Please ask for: Mrs D Johnson
Email: daun.johnson@arun.gov.uk
Telephone: 01903 737762
Our Ref: BN/26/22/PL
Your Ref:
Date: 4th March 2022

Application for Planning Permission

Development: Construction of 1 No. two storey detached dwelling house on existing paddock. This application is a Departure from the Development Plan and is in CIL Zone 3 and is CIL Liable as new dwelling.
Location: Land East Of Eastmere House Eastergate Lane Eastergate PO20 3SJ

Ground Floor Plan as proposed Scale 1:100

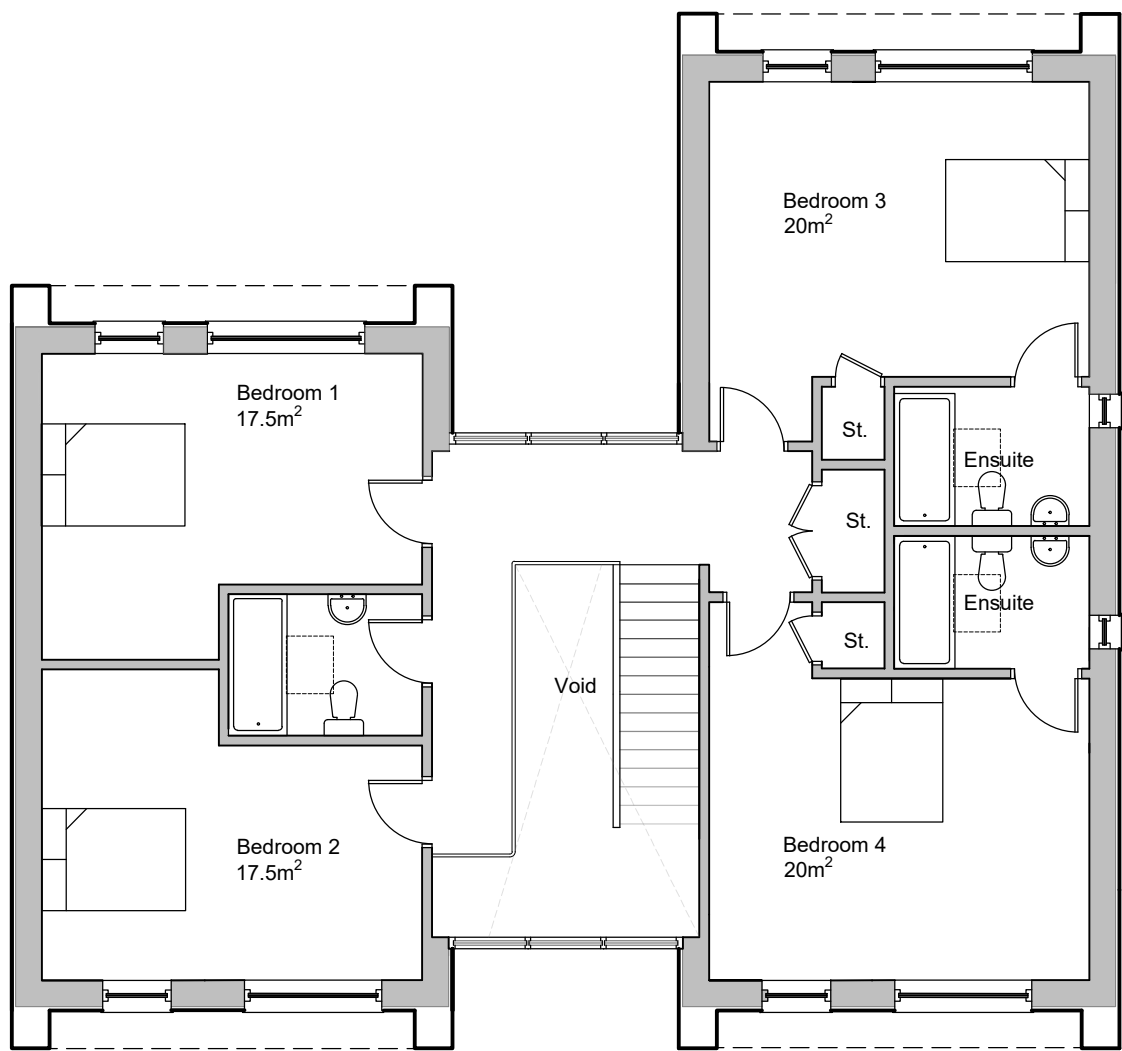
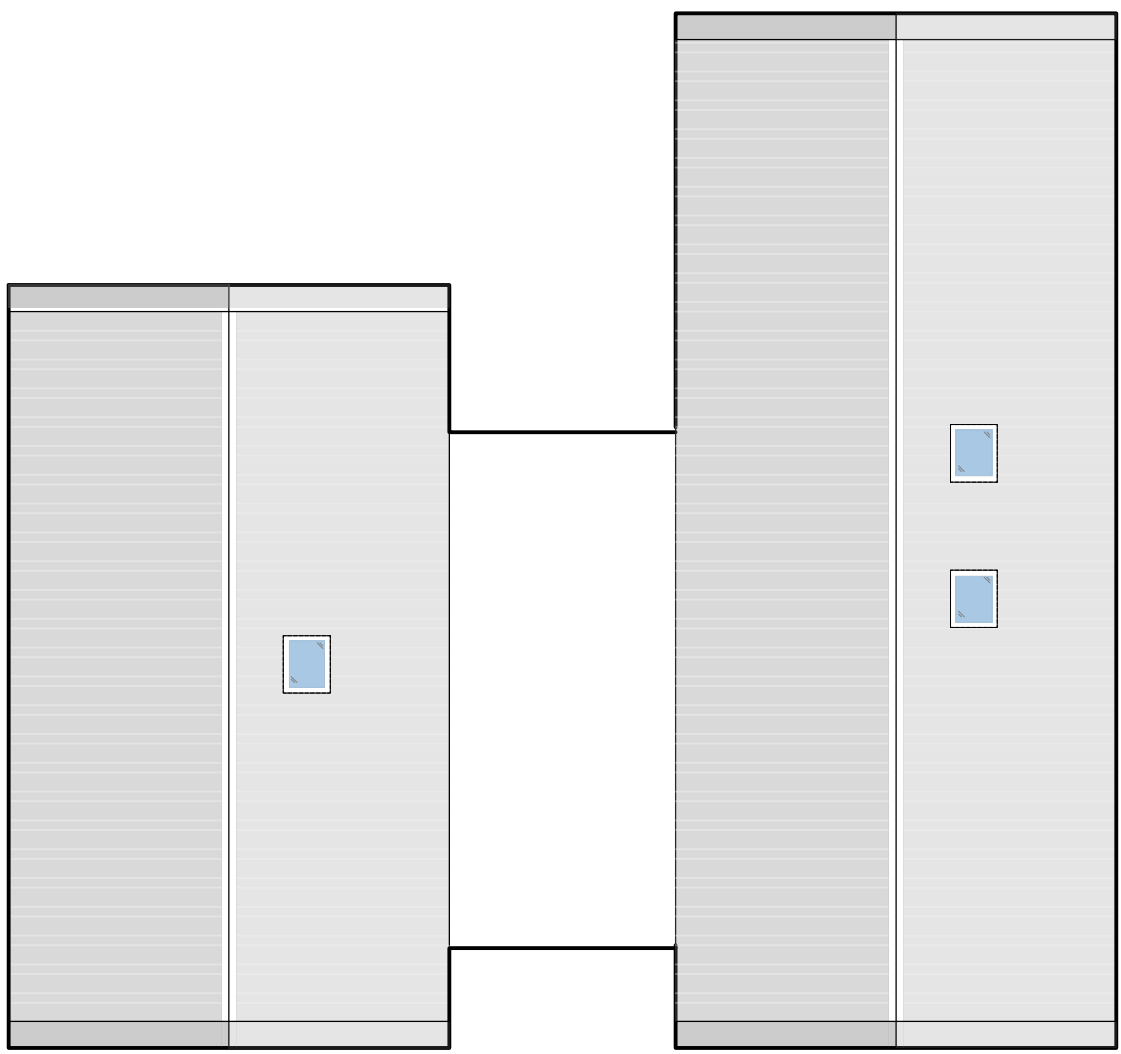
The ground floor plan is not showing on the plan. Please ensure the plan is showing.
